From: Amanda Scholes on behalf of Planning.Responses
Sent: 18 February 2020 08:42
To: Planning Scanning
Subject: FW: Barnham Court - Planning Application: BN/96/19/L - Detail of Joinery and Paint Colours

From: Andrewmartin45 <[REDACTED]>
Sent: 20 January 2020 16:44
To: Planning.Responses <[REDACTED]>
Cc: Maria Tomalova <[REDACTED]>
Subject: Barnham Court - Planning Application: BN/96/19/L - Detail of Joinery and Paint Colours

| Title                                                                                                                         | West Orangery Proposed |

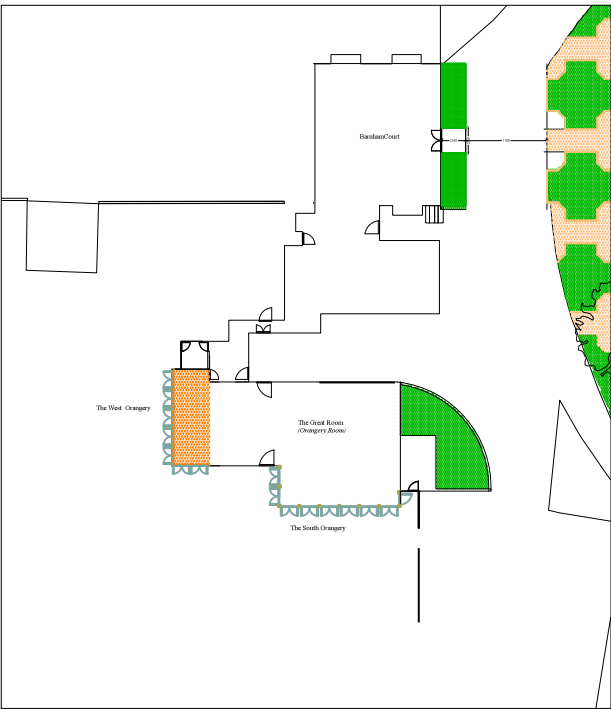
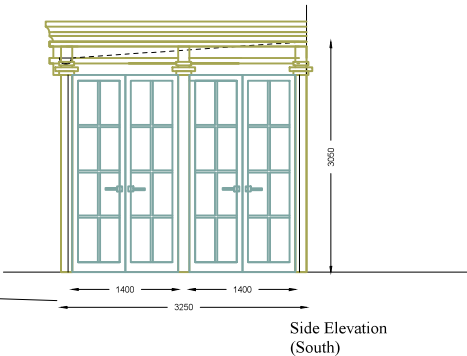
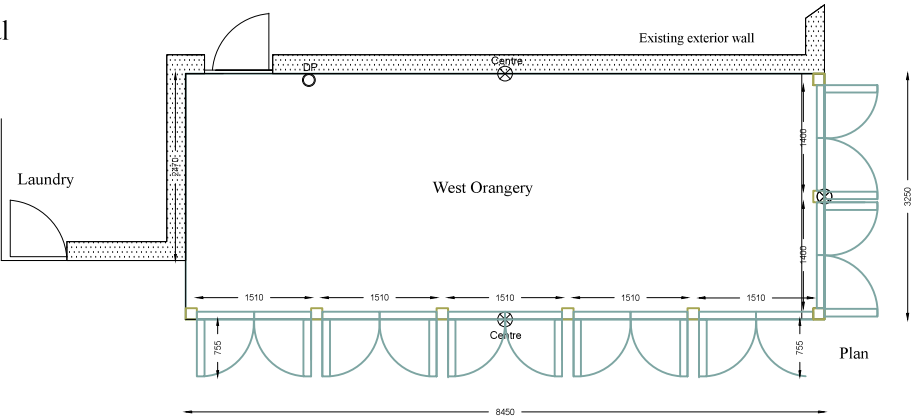
3 No development shall commence until detailed drawings showing how the western orangery will join up to the existing single storey laundry structure, especially with regards to the existing roof structure and associated rainwater goods, have been submitted to and approved by the Local Planning Authority. Details of this junction should be provided at the scale of 1:20.

4 No development shall commence until detailed drawings of all the joinery including the doors and oak timber posts with Doric columns and a new door from the opening from the existing garage/service building into the western orangery along with details of the proposed colour have been submitted to and approved by the Local Planning Authority. Drawings should be provided at an appropriate scale and provide details of the glazing/glazing bars.
